Yapton Parish Council

Response to Planning Reference Y/98/18/RES

Land off Burndell Road, Yapton

Approval of reserved matters (access, appearance, landscaping, layout and scale)

PROPOSED SITE PLAN

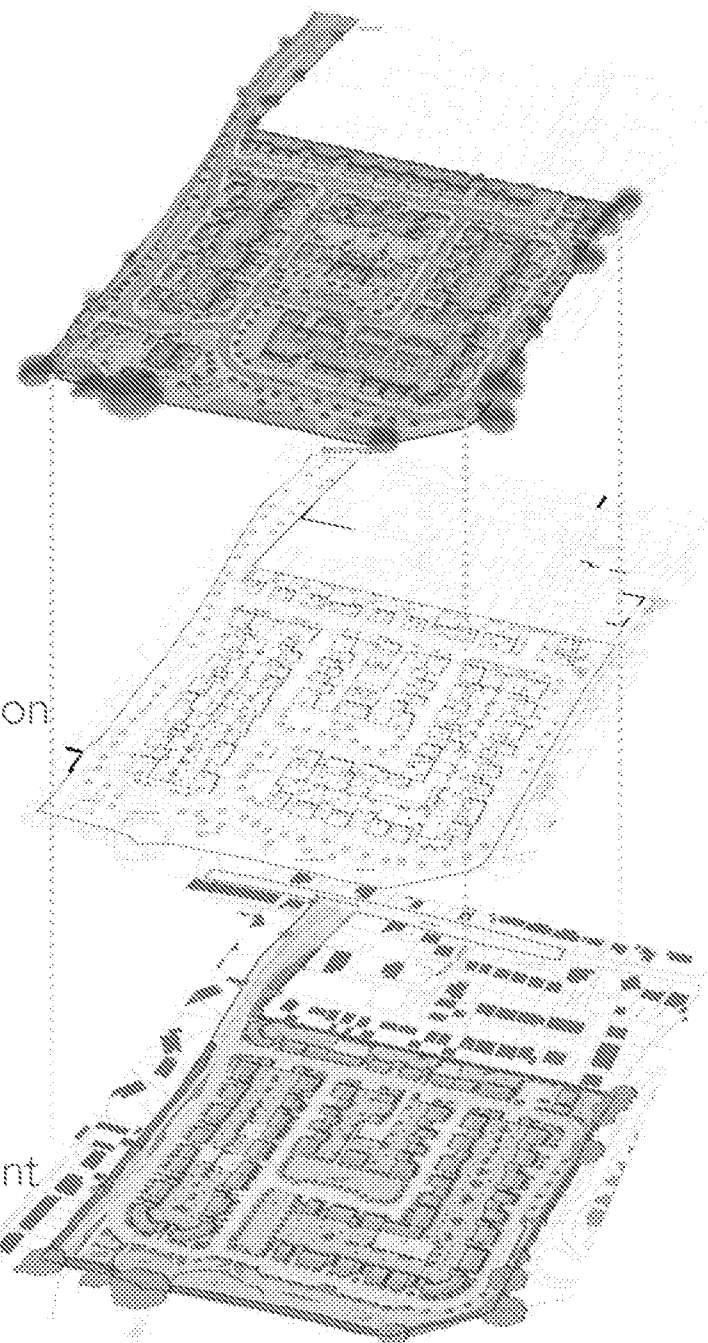
YPC accept the density of 108 units. However, YPC would expect the proposal to reflect a scheme that softens the high density numbers through careful distribution of housing type and sensitive placing of units within the street-scene.

YPC appreciate that the housing faces outwards but would seek a more varied site line from street level, reflecting the irregular placing of housing fronting key roads and lanes throughout the village. YPC therefore seek that the units are varied in depth along the main streets/roads to ensure a more rural feel opposed to regimented urban street scene. The use of front gardens and green laybys should be promoted to soften the streetscape and enhance Yapton's heritage and village status. This is clearly reflected in Emerald Gardens and the proposed design statements of both Y/1/17/OUT and SD7.

YPC would also seek that the amenity space is provided as a more central 'village green' effect, providing a central focus to the scheme and a formal shared open space which would promote a shared community experience.
